Our Ref: Y/15/11/
Your Ref:

19th May 2011

**Change of use from (C3) dwelling to (D1) day nursery
Longacre Bungalow Maypole Lane Yapton**

Block Plan 1-200 @ A1

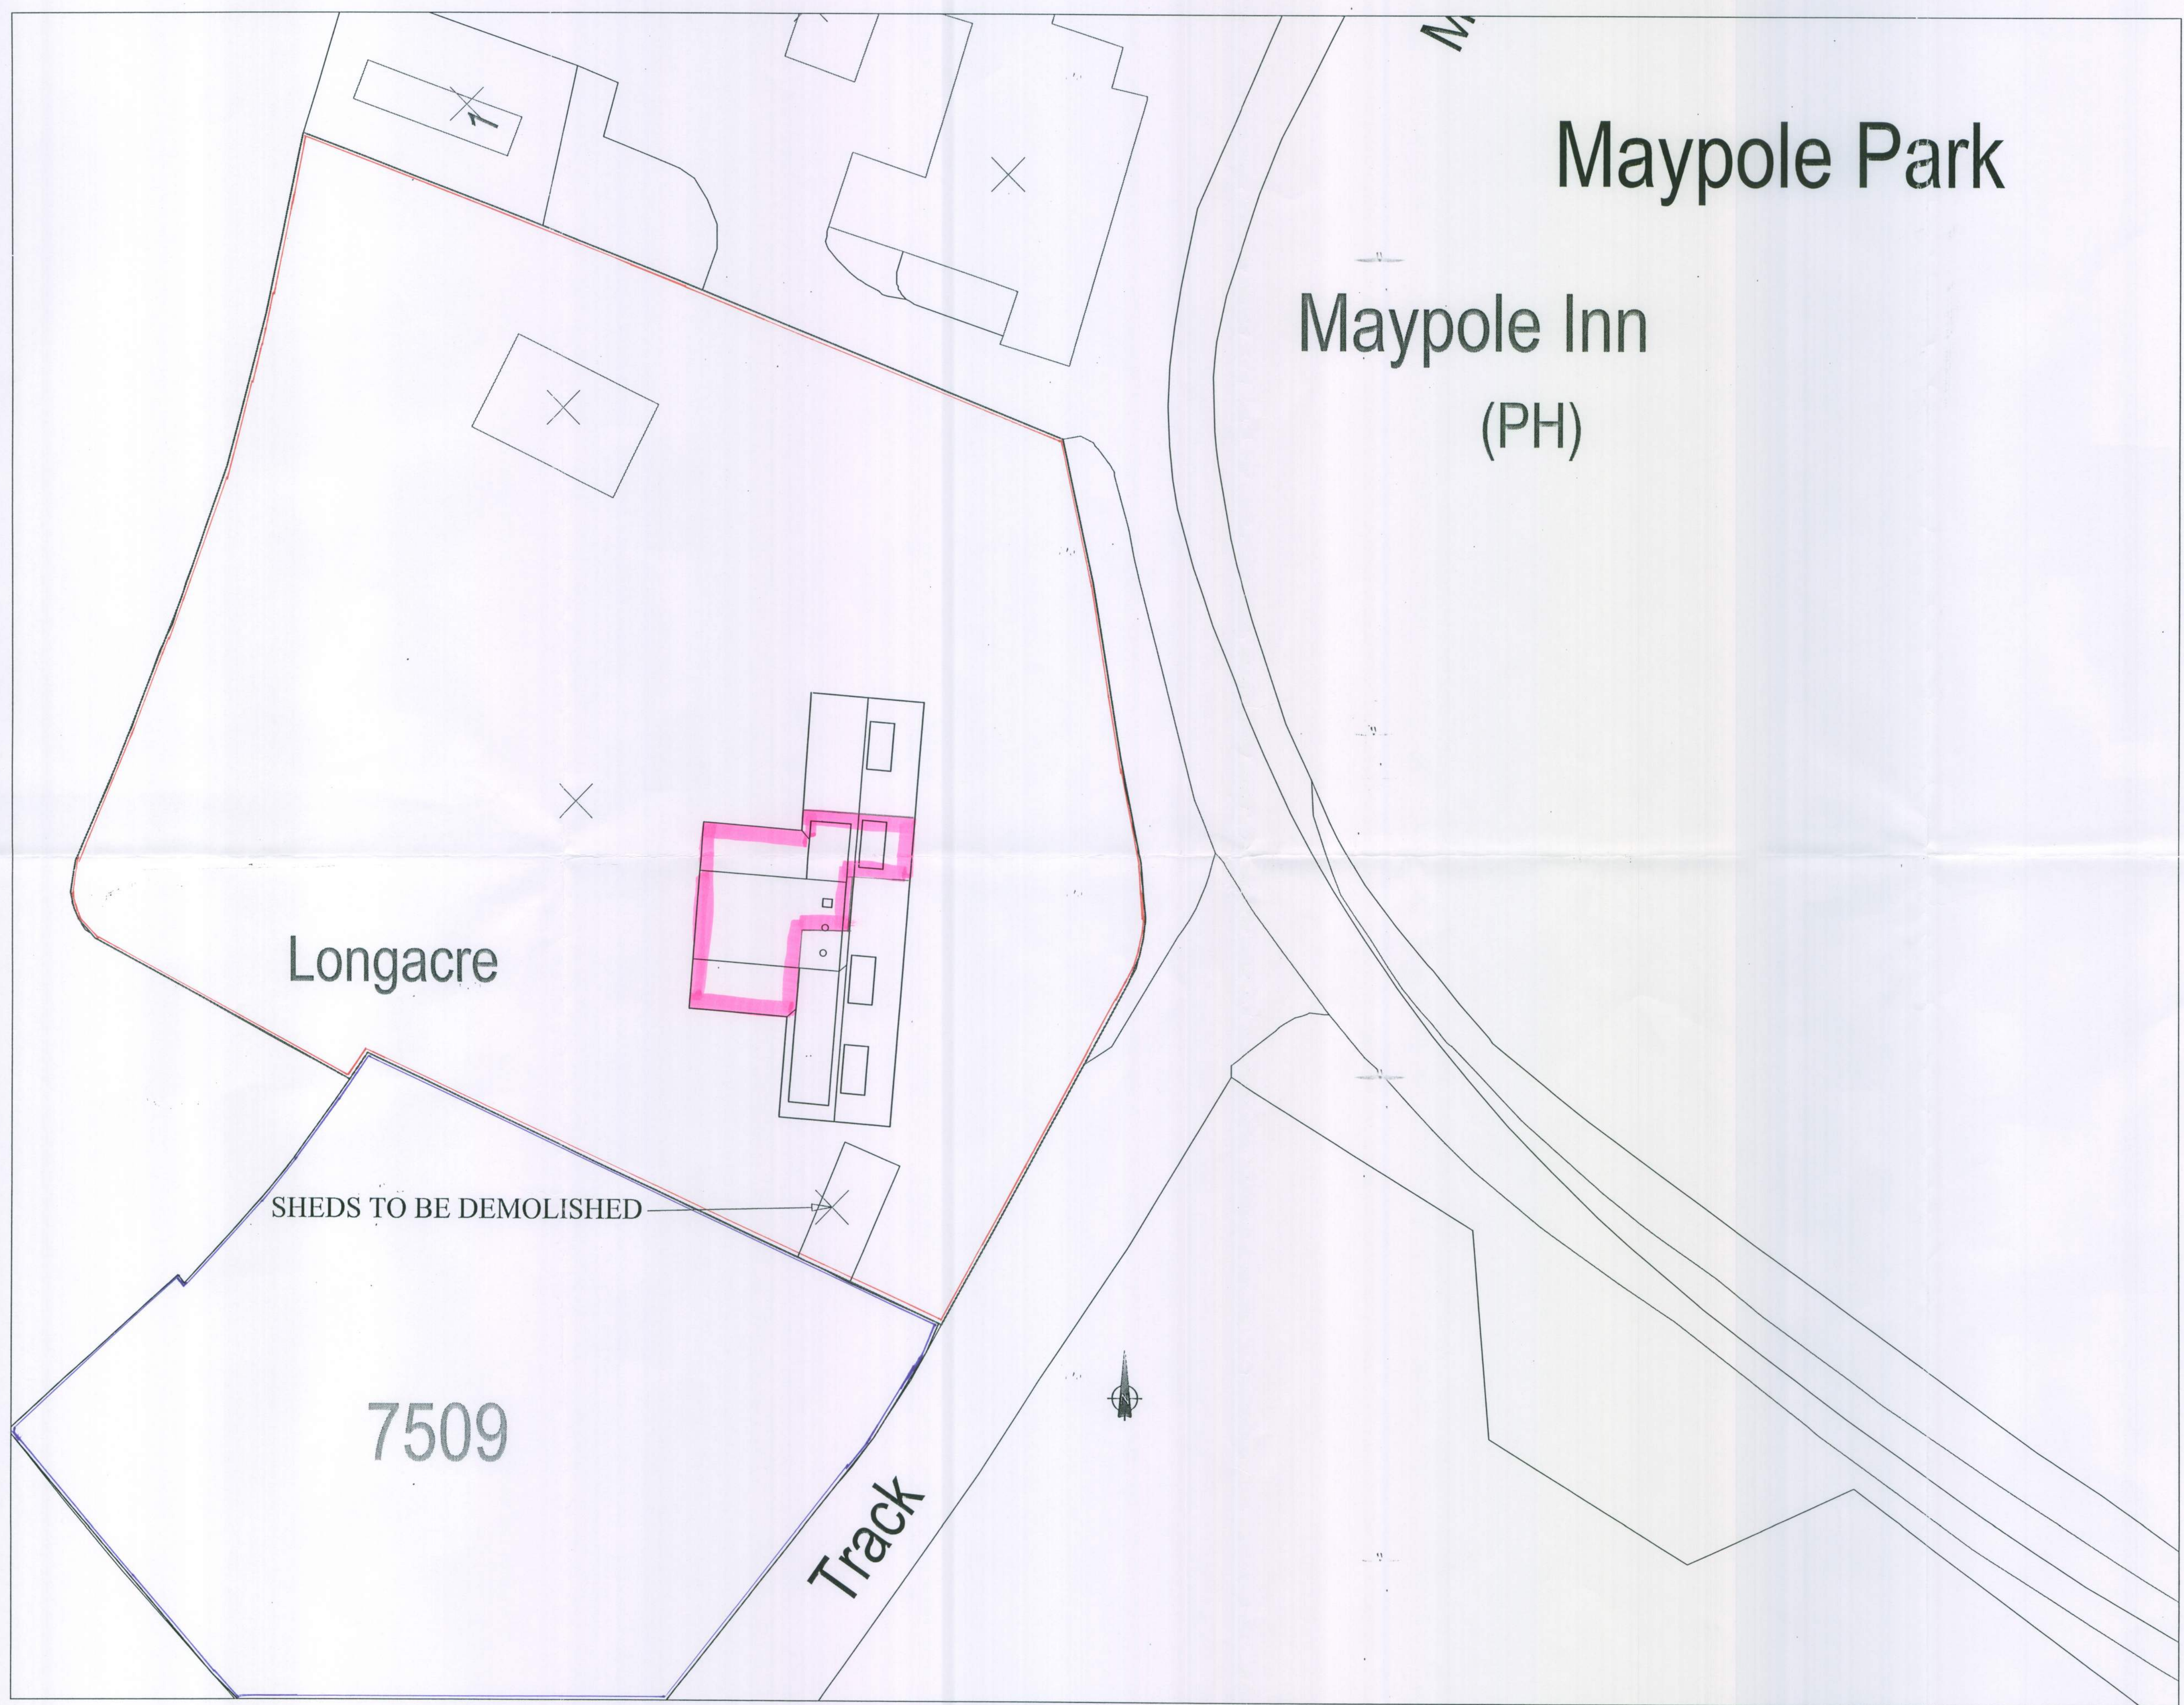
I require 1 electronic or 3 paper copies of a revised block/site plan (1:500) to show both the red and blue edging and the proposed works clearly highlighted as shown on the previous plan, in accordance with the guidance notes available on our website detailed below (click on National List).

Proposed First Floor Plan

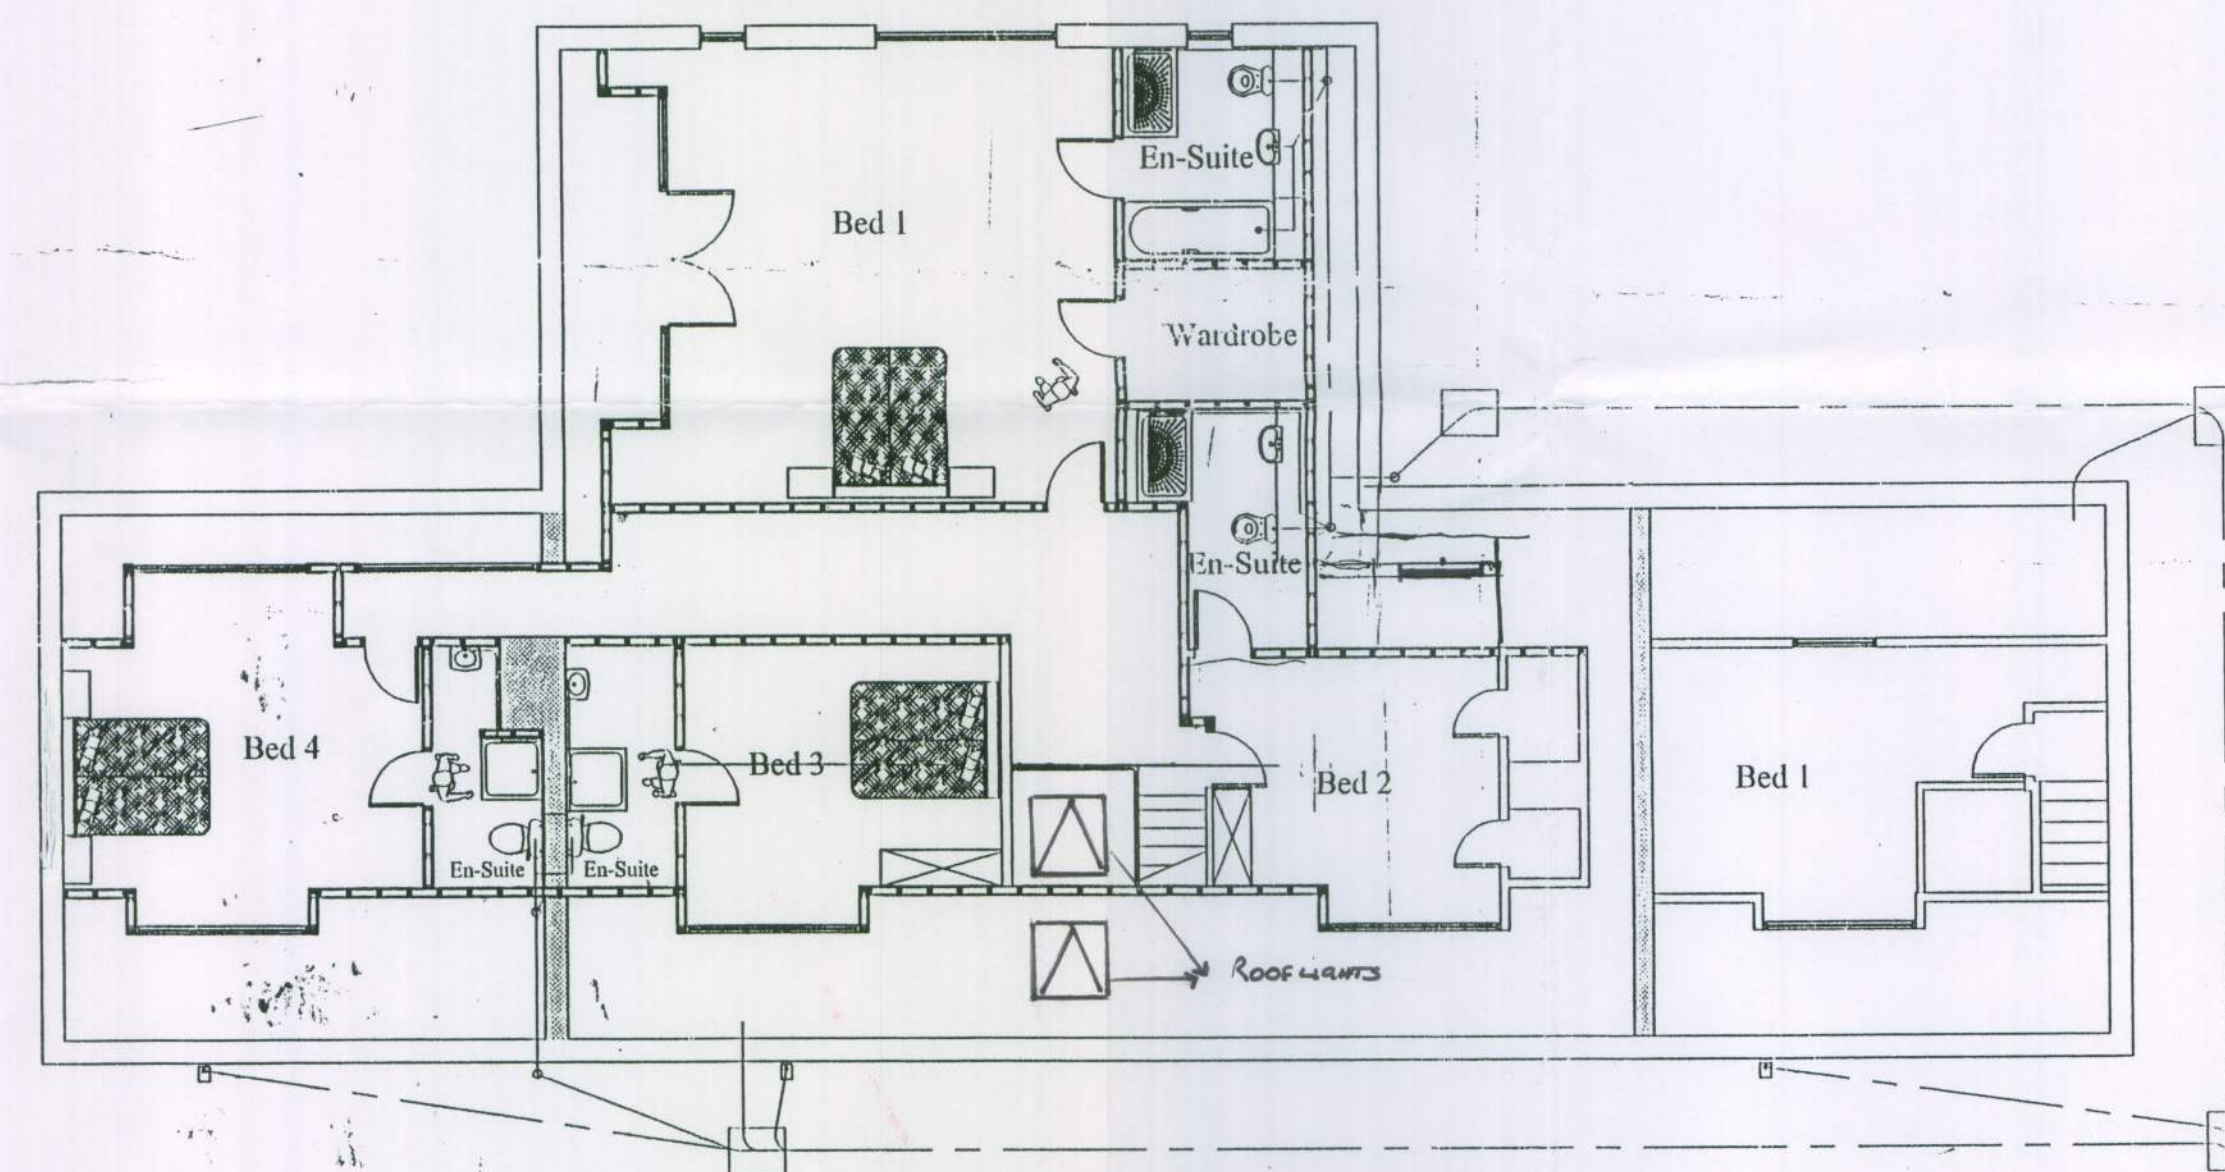
There is a window shown on the proposed first floor plan (bedroom 4) which is not shown on the proposed south elevation. Please amend.

Proposed East Elevation

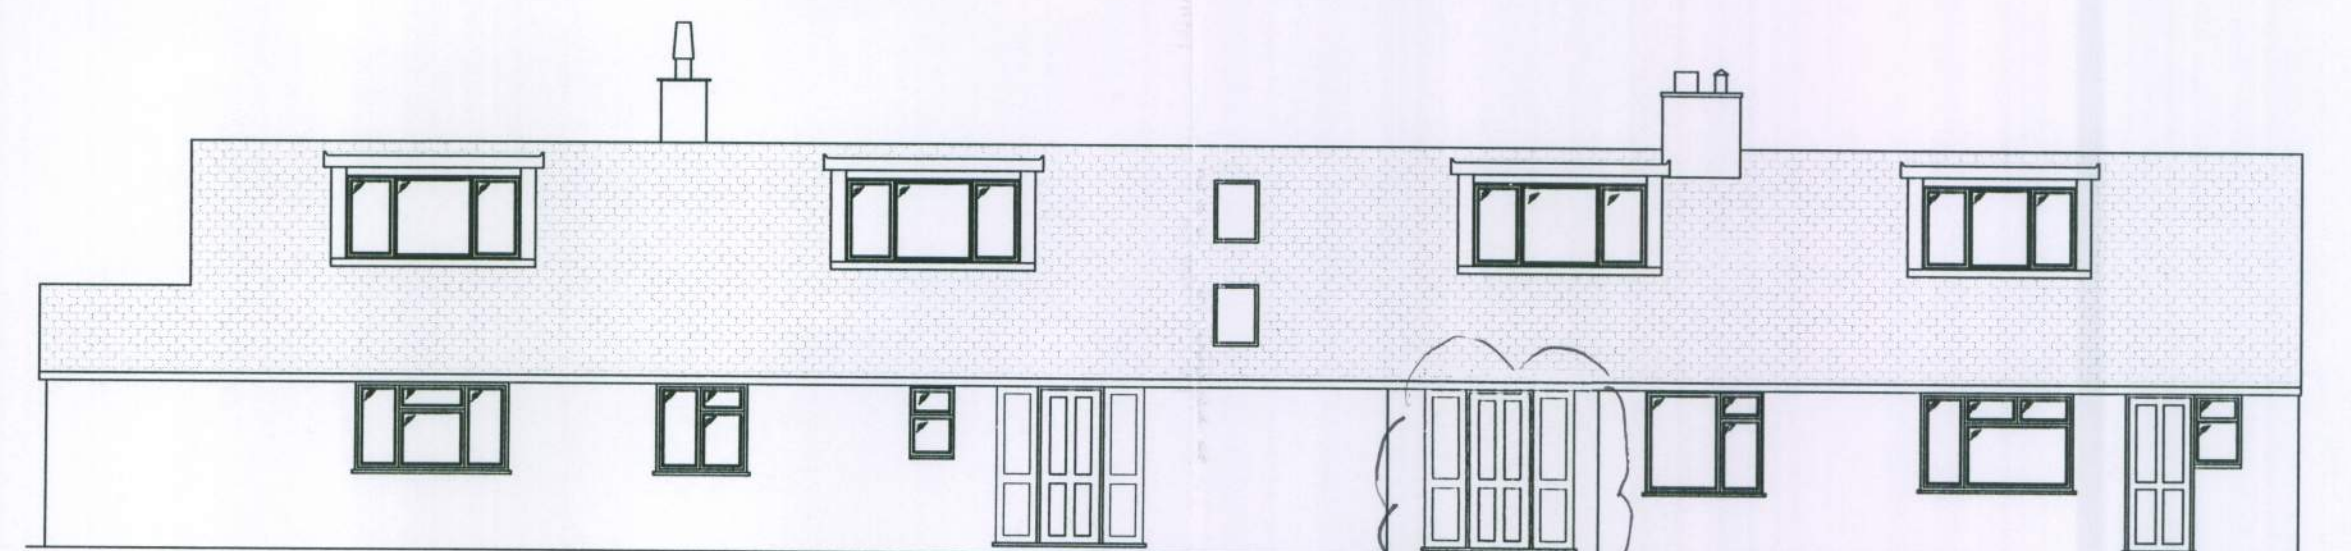
There are windows and a door shown on the proposed east elevation which do not match the windows and door detailed on the proposed ground floor plan. Please amend.
